Letter No. BC1 / 5424 / 05

Sub:-CMDA - Area Plans Unit - B Channel  
(South/Central/North) Planning Permission proposed  
construction of Revised Commercial office complex  
floor residential / commercial building with Dwelling  
Units at Nandambam in Particulars -  
Called for - Reg - Reminder - Reg.

office complex  
S.No. 6745  
Block No. 143 of  
T. Nagar,  
Chennai

still parking floor plan

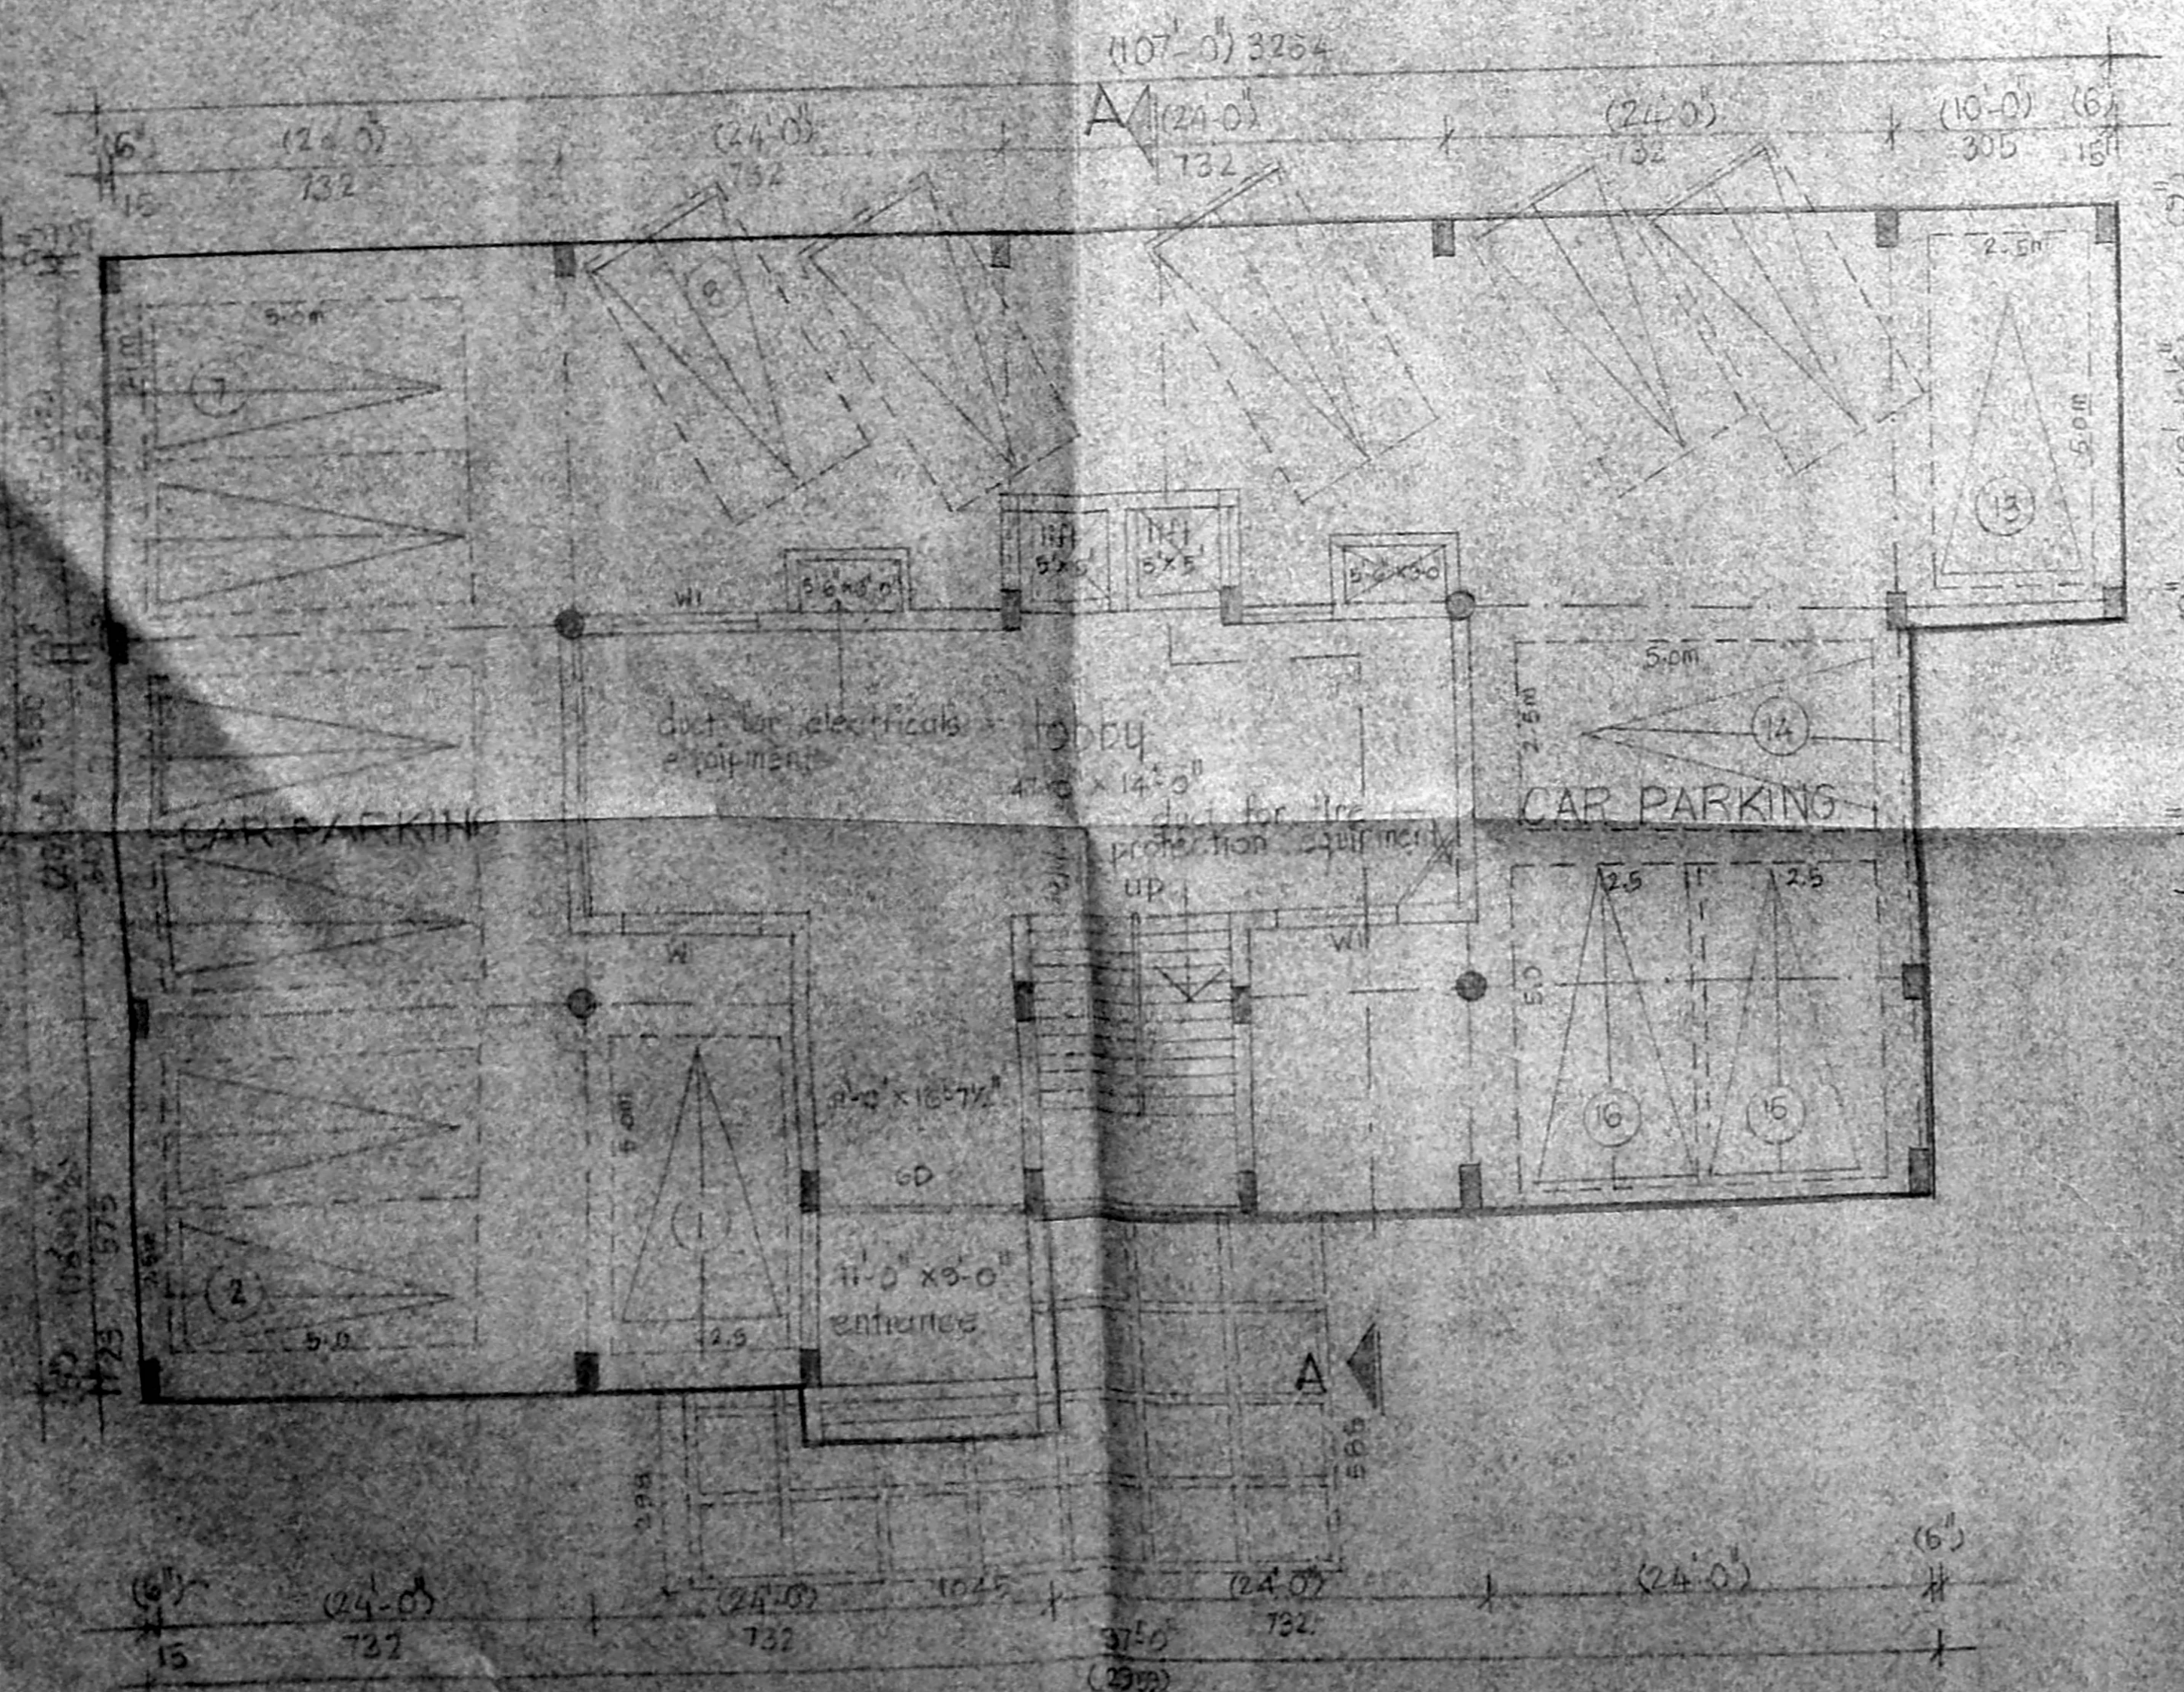
1. The size of portico not shown in the site plan.
  2. Area statement needs correction.
  3. Also to furnish Building Permit.
  4. Regarding OSR, the TNSEB in L.S. No. 66/98/SP dt: 17.11.03, has stated that, it undertakes to handover the OSR area to Corporation of Chennai within 3 months from the date of completion of the proposed development.
- Hence the same may be clarified whether OSR has been handed over to Corp. of Chennai
